# MDP23002-R3-MDDP.pdf Markup Summary

EL PASO COUNTY, COLORADO
PRE DEVELOPMENT DRAINAGE MAP

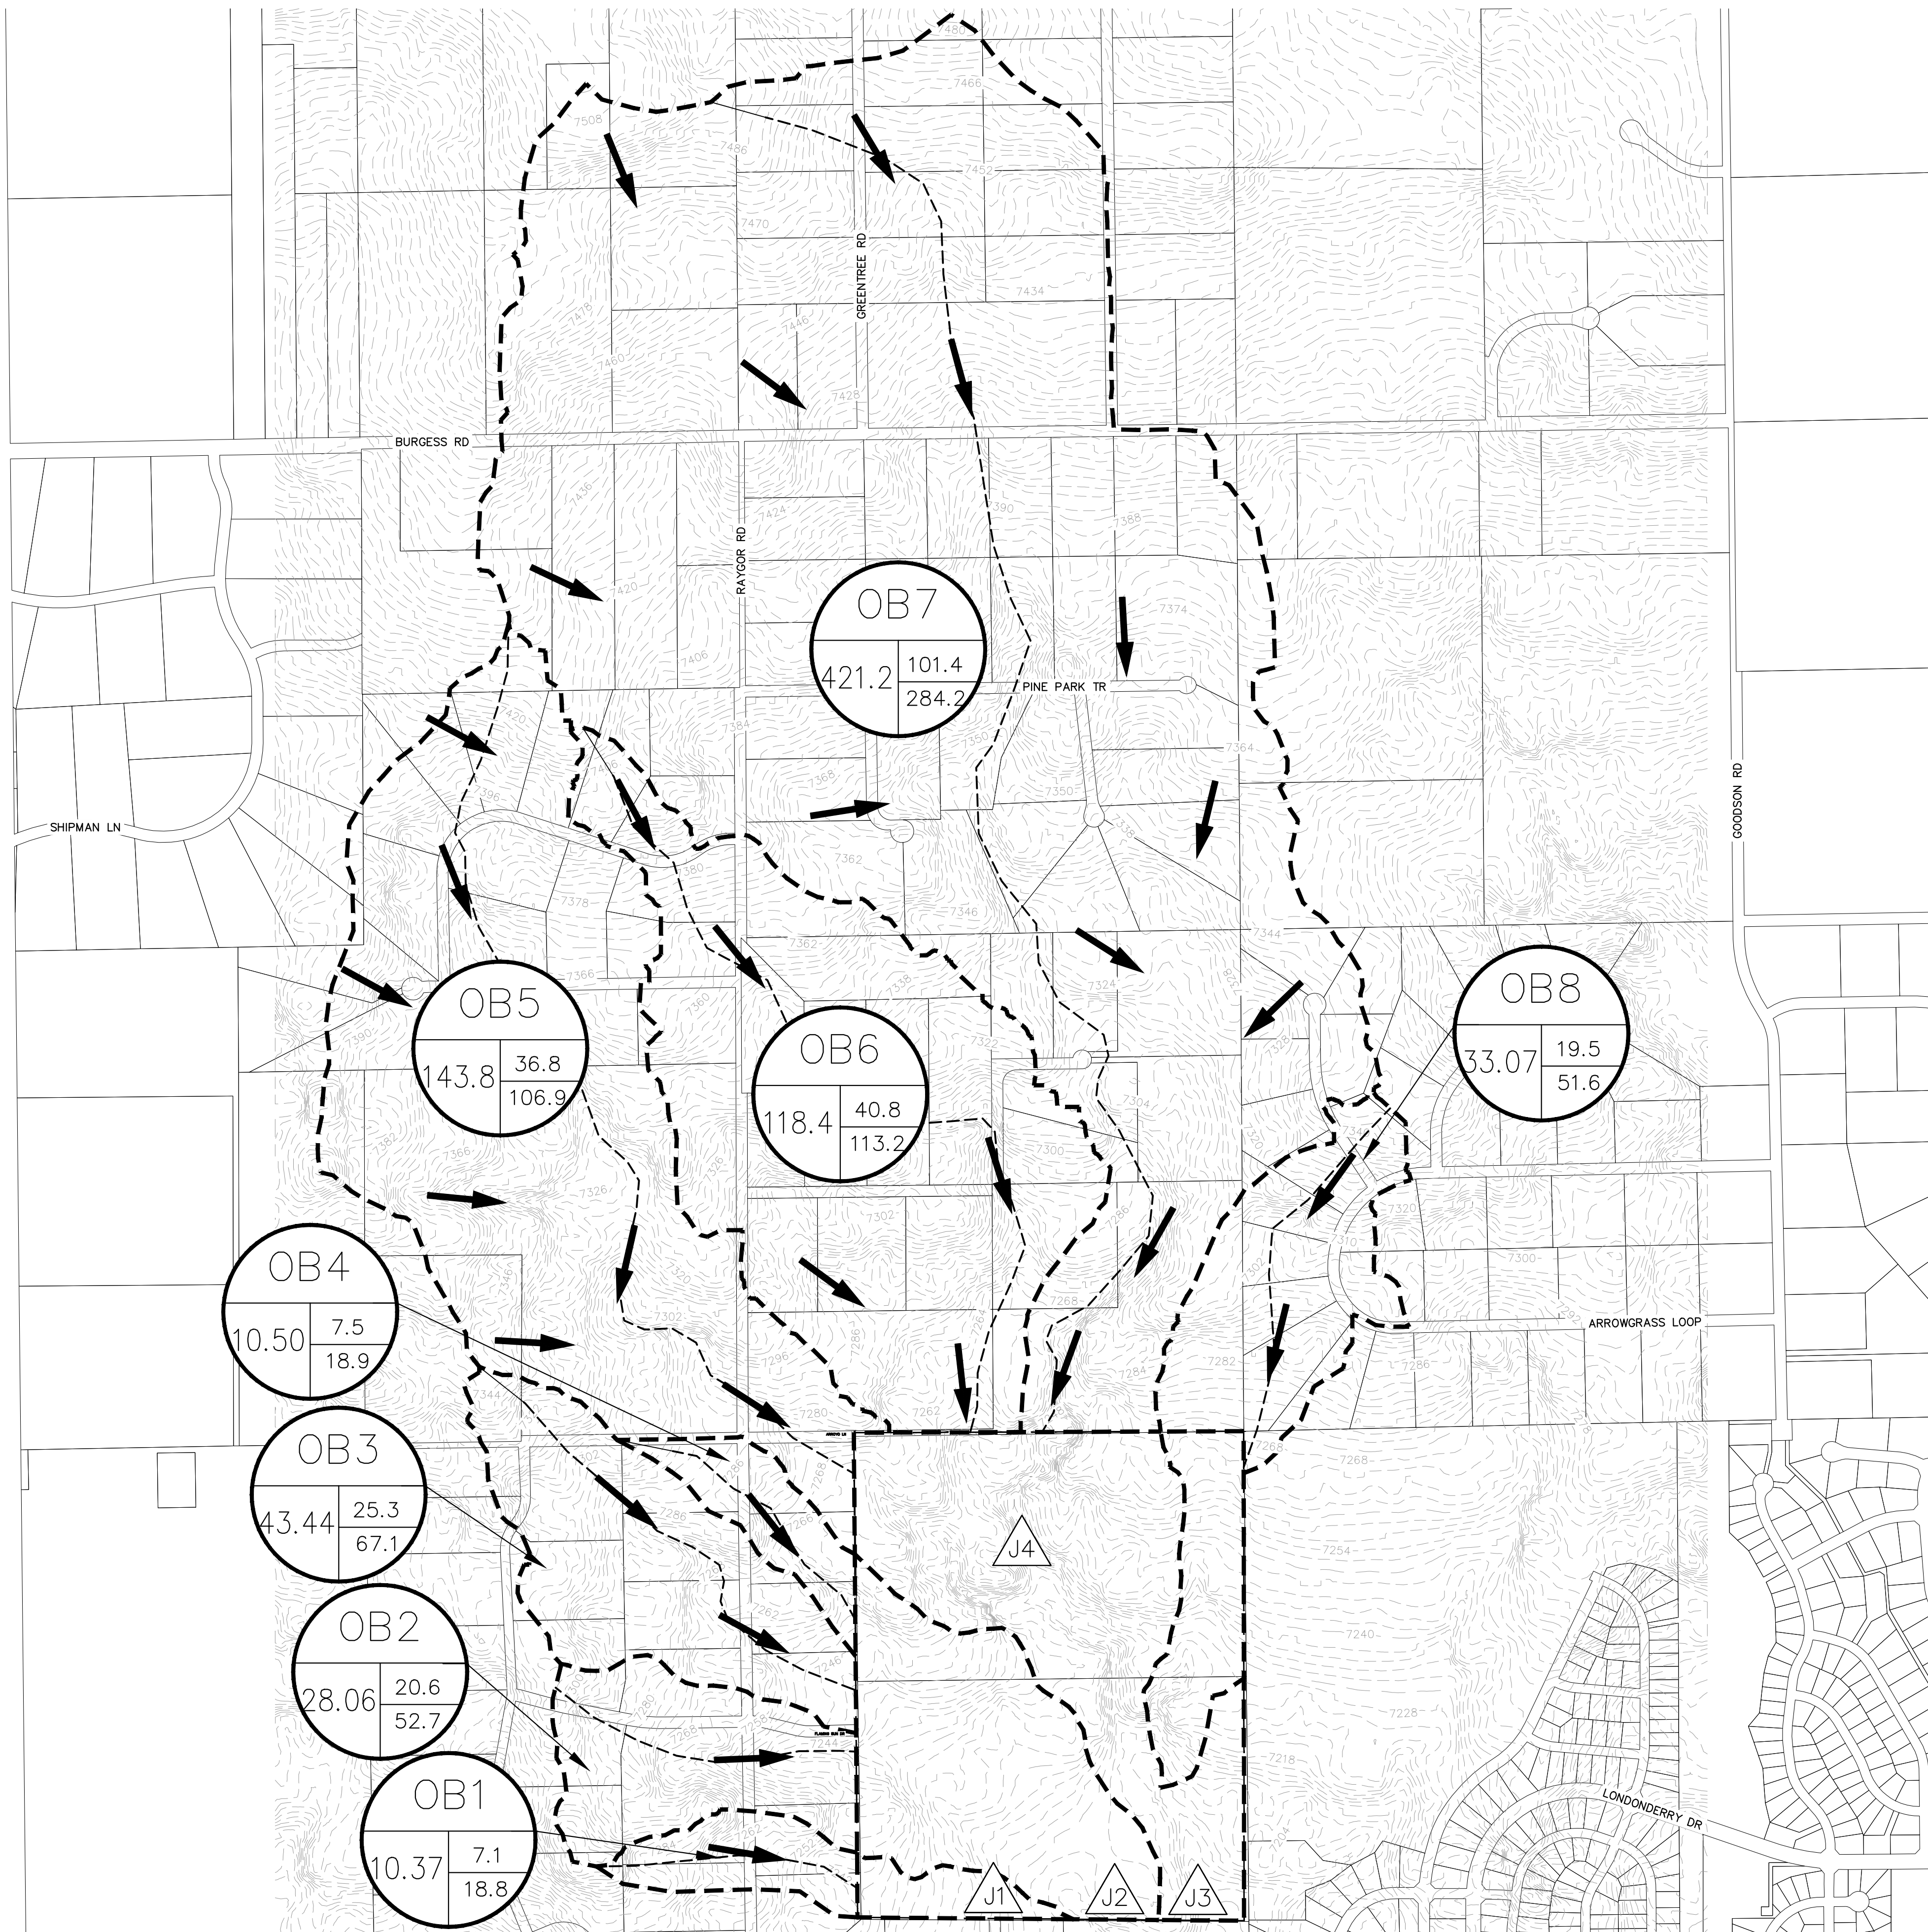
(see Pre-development Drainage Plan)

EAGLEVIEW
EL PASO COUNTY, COLORADO
POST DEVELOPMENT DRAINAGE MAP

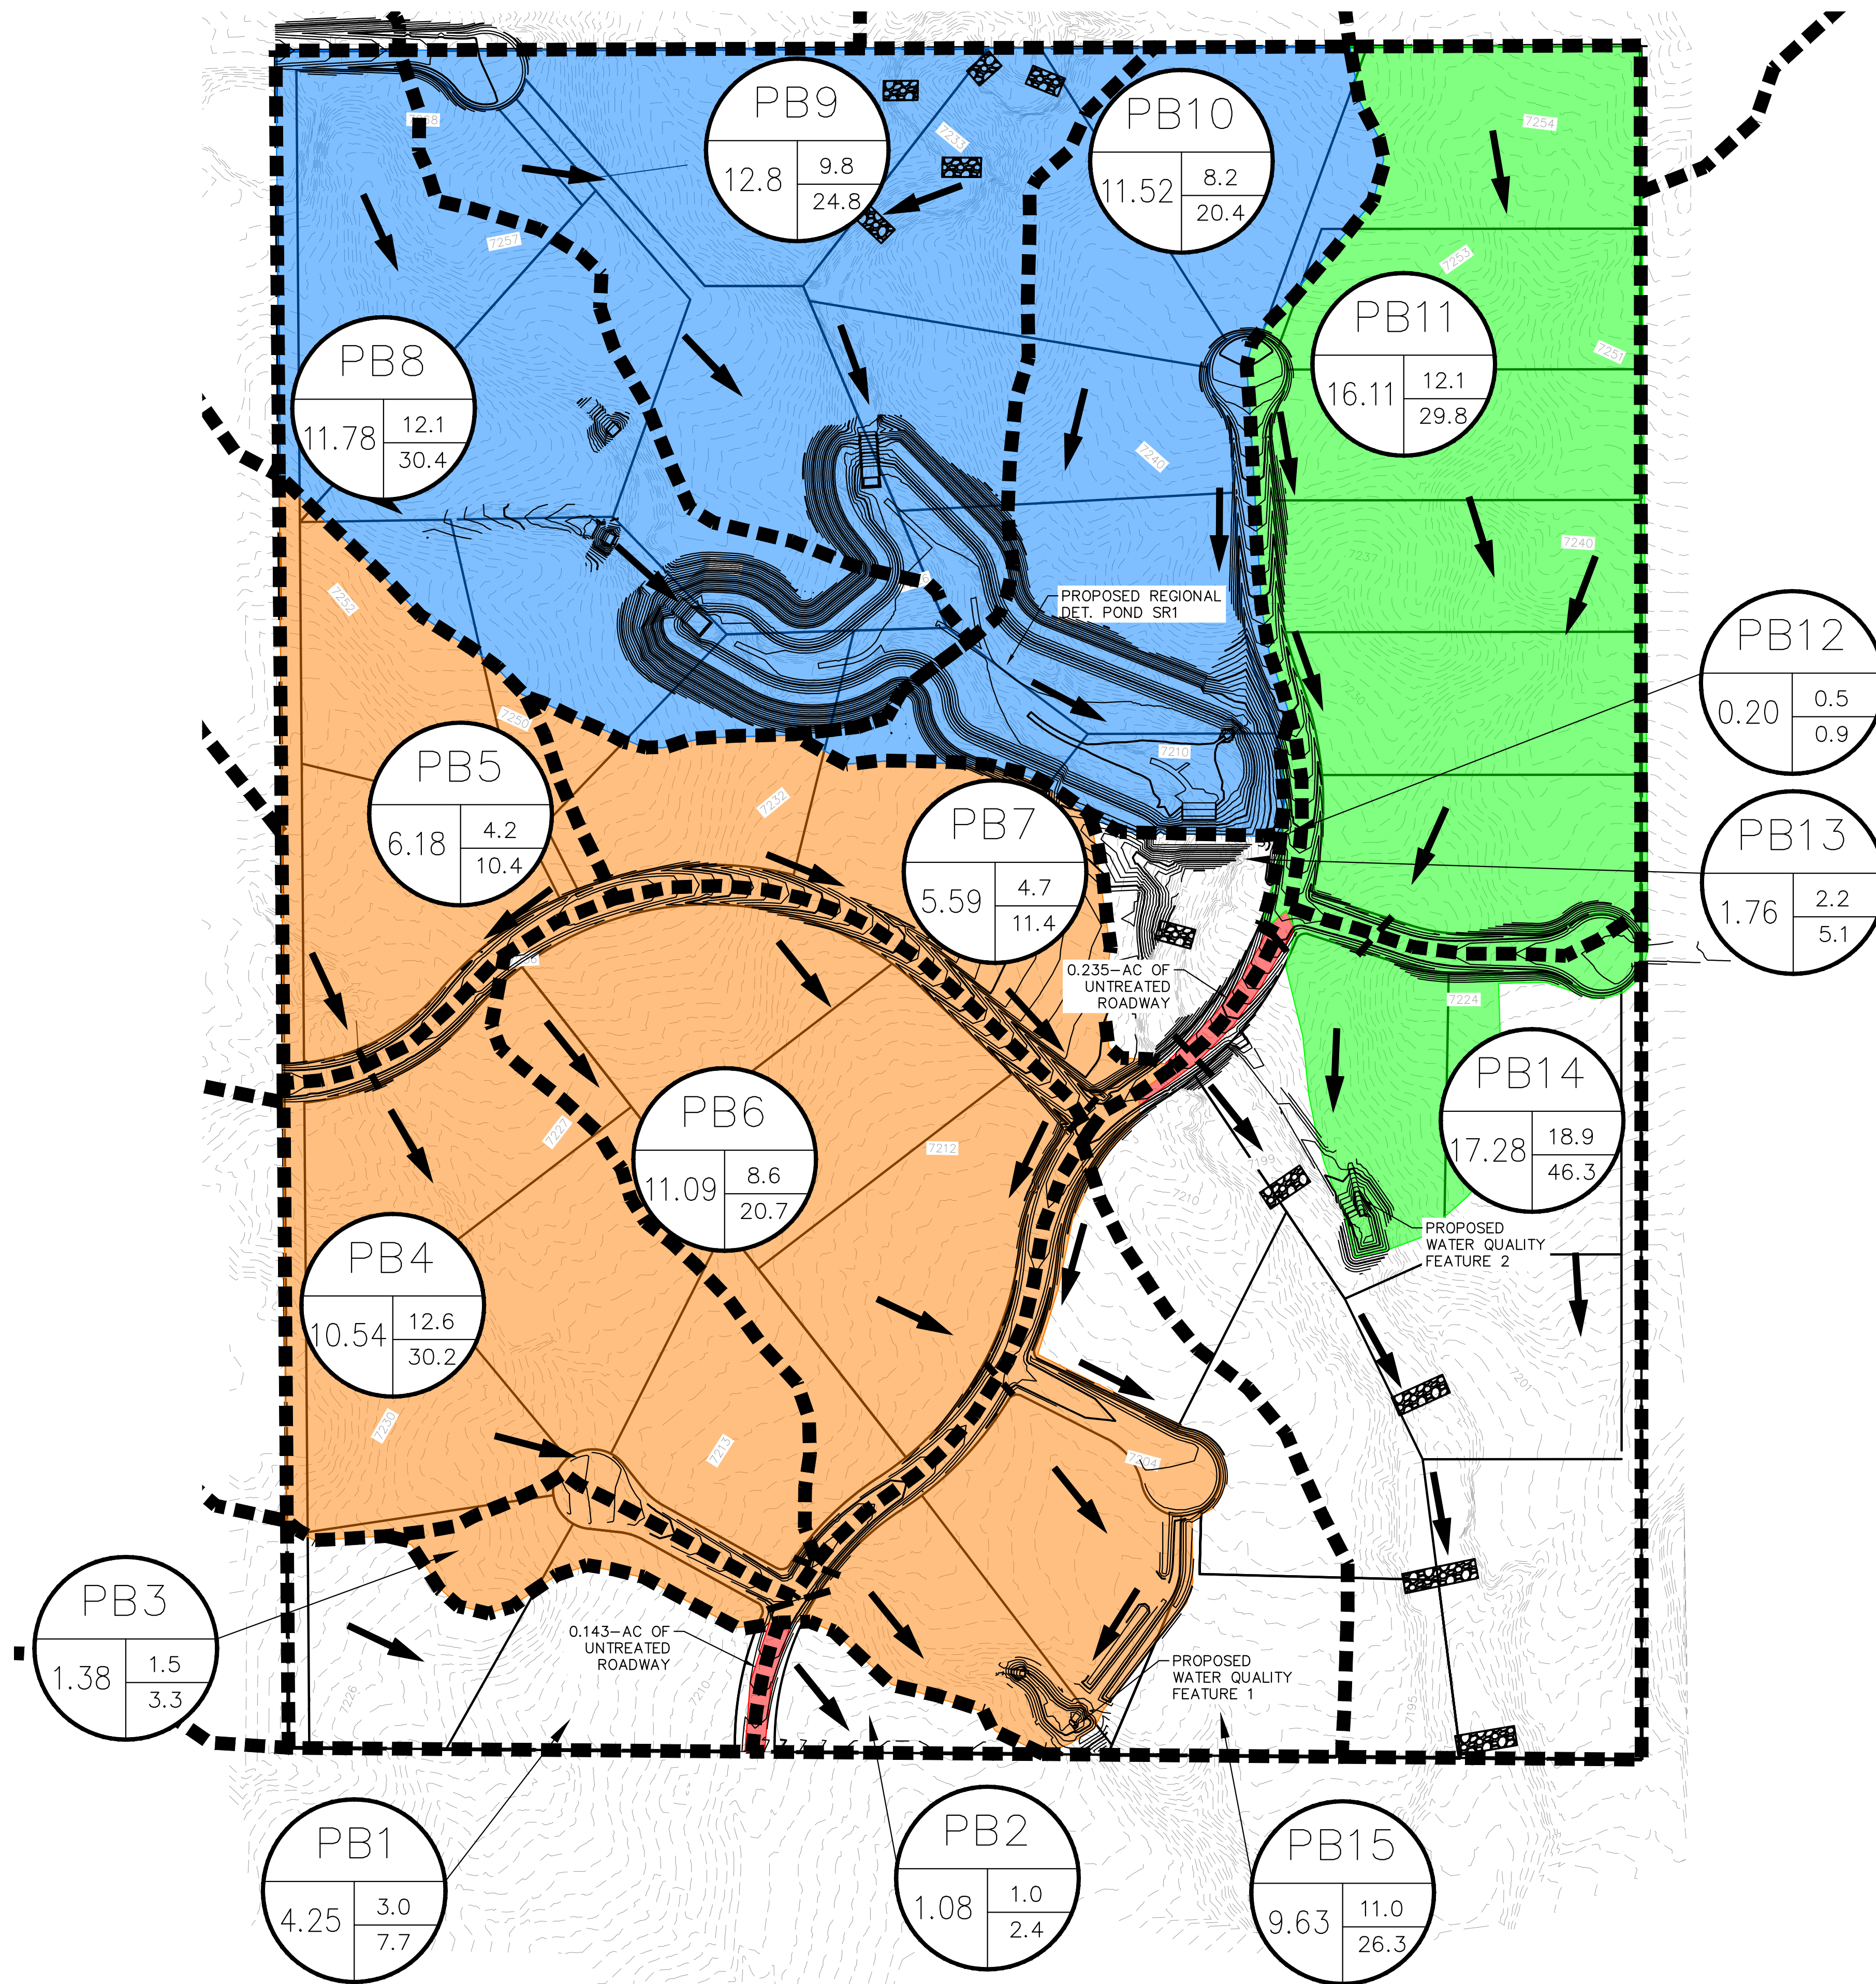
Basin P7 does not appear to match the label on the proposed drainage map.

(see Post-development Drainage Plan)

(P8?)

Overview Map - PBMP Tributary Areas (Revised)

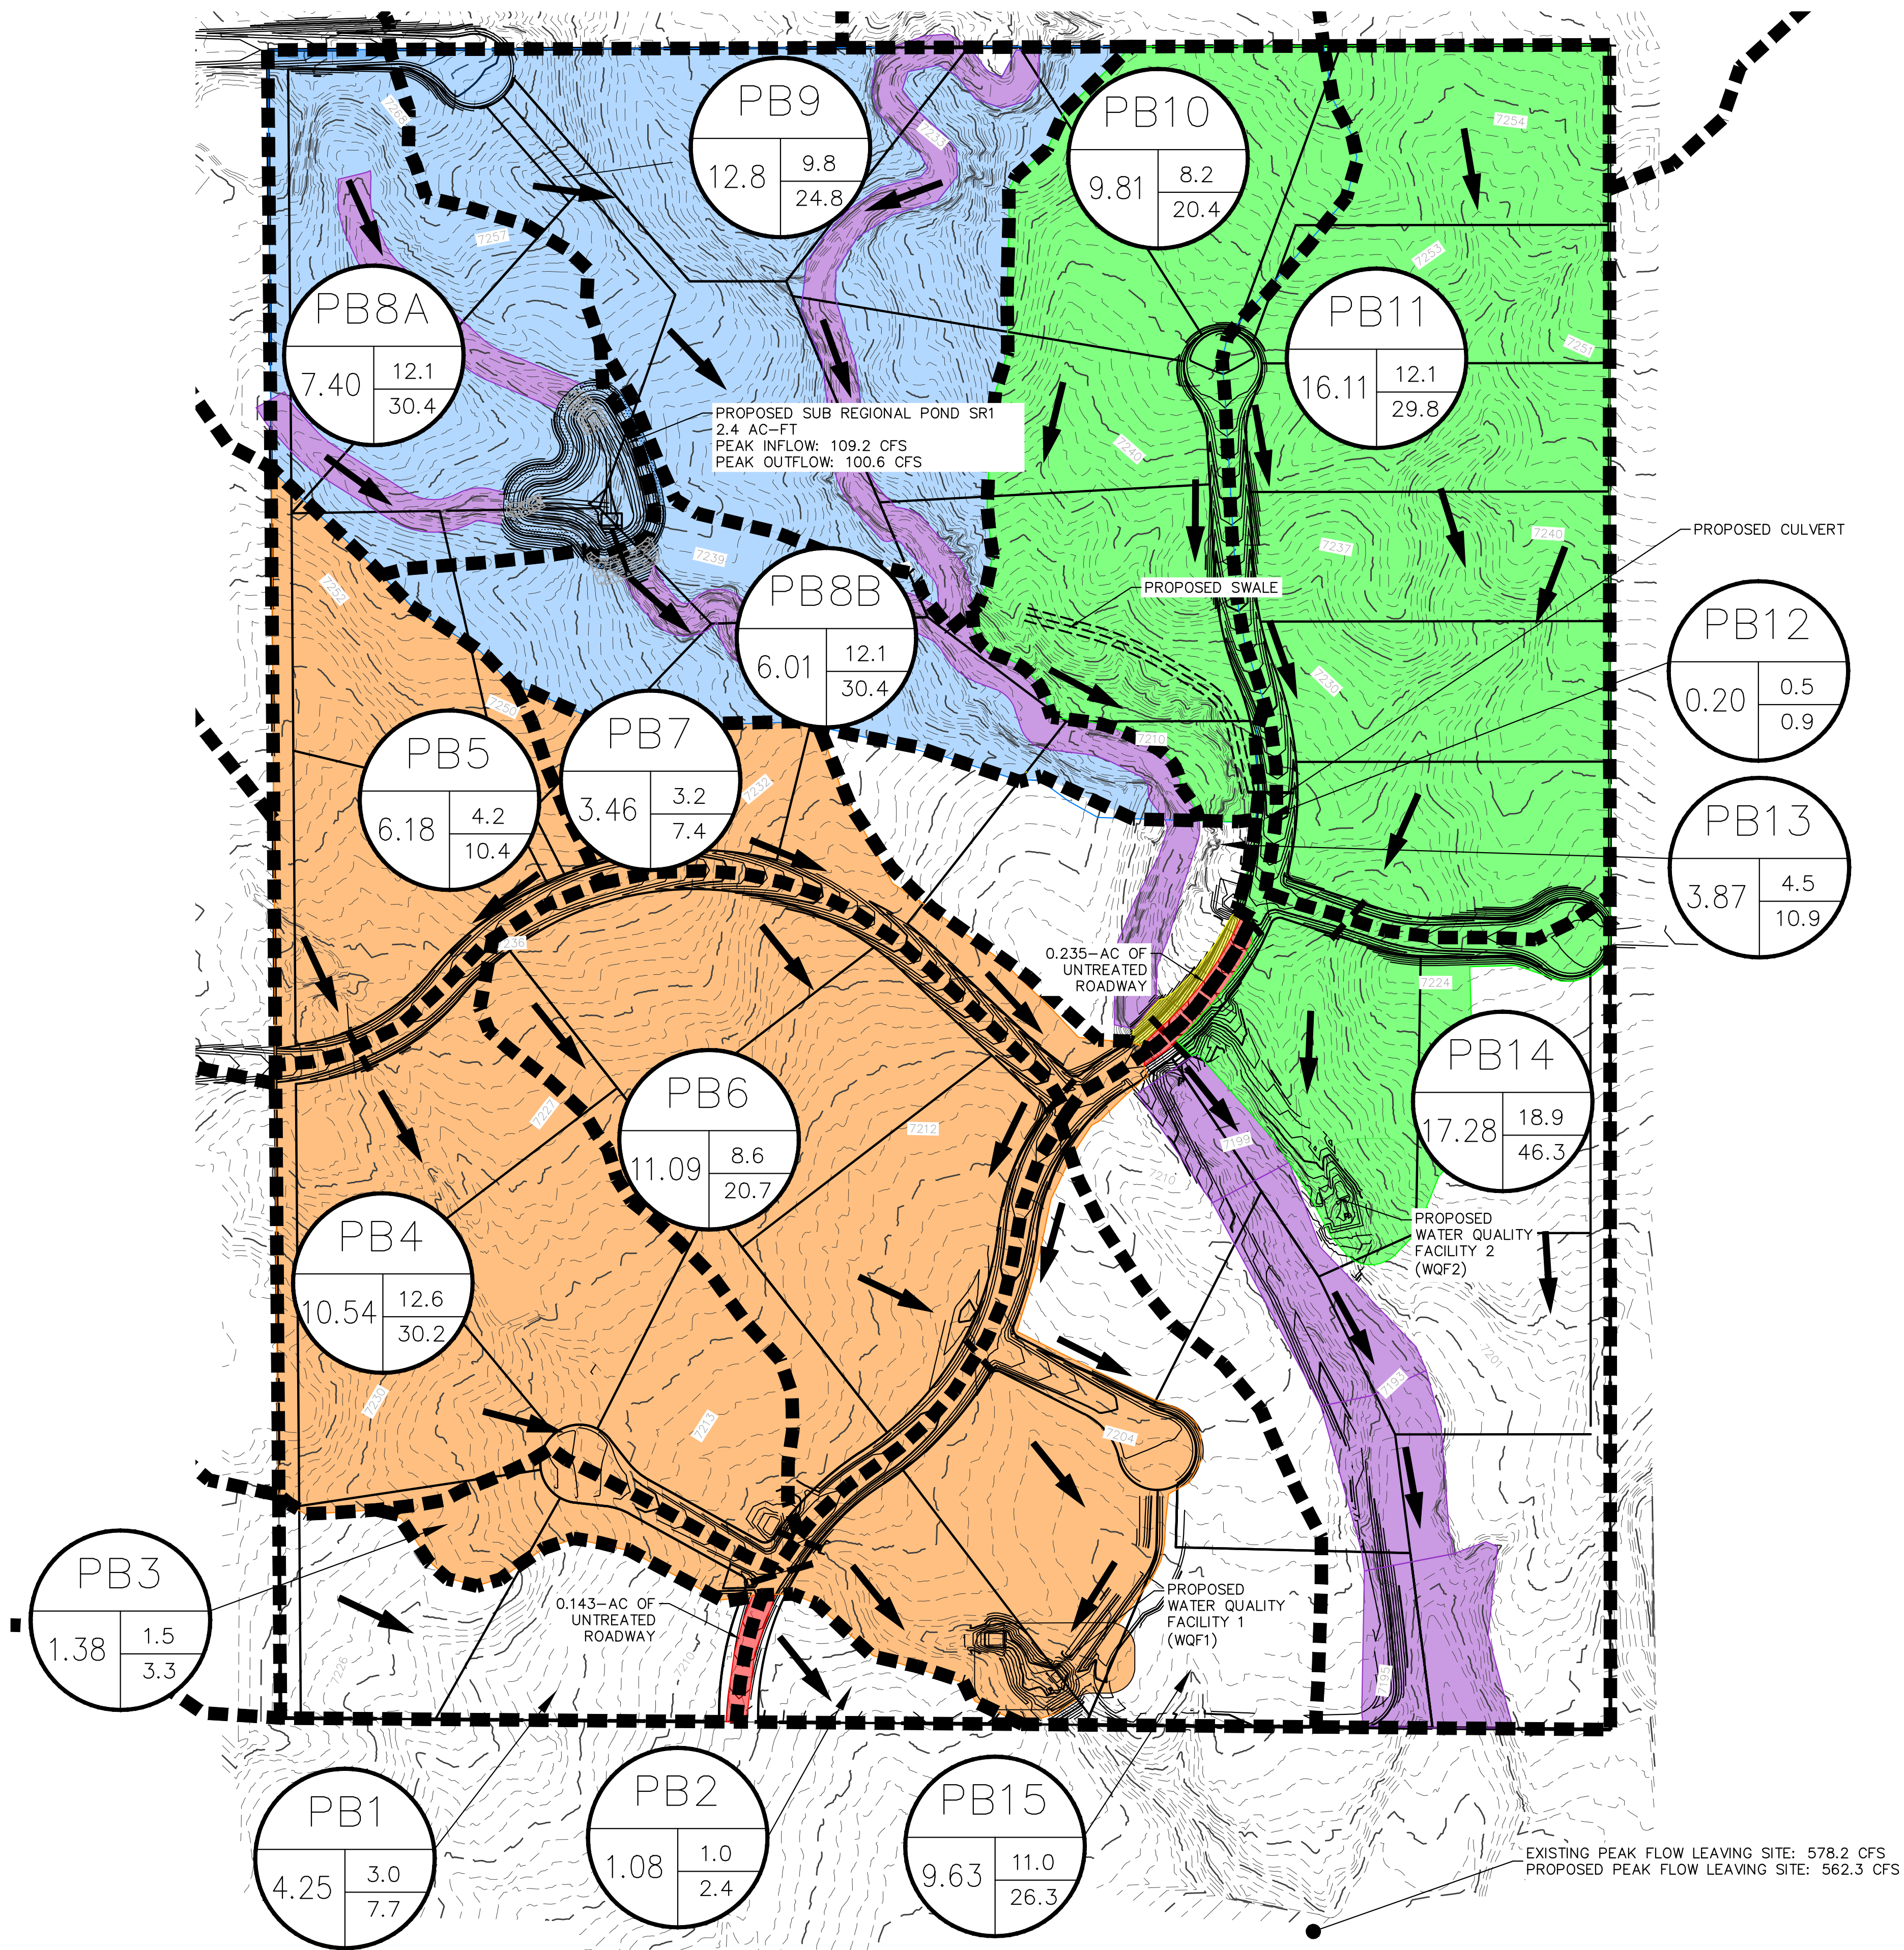
This value may need to be updated again per my comment on the "Overview Map - PBMP Trib Areas."

All areas of disturbance must be accounted for with either WQ treatment or an applicable WQ exclusion. Per my Review 2 comment, this area of grading needs to be shaded too, not just the red area that you have now shaded since last submittal. Please feel free to contact me if you have any questions.

Update total value per my comment above about the northwestern cul-de-sac.
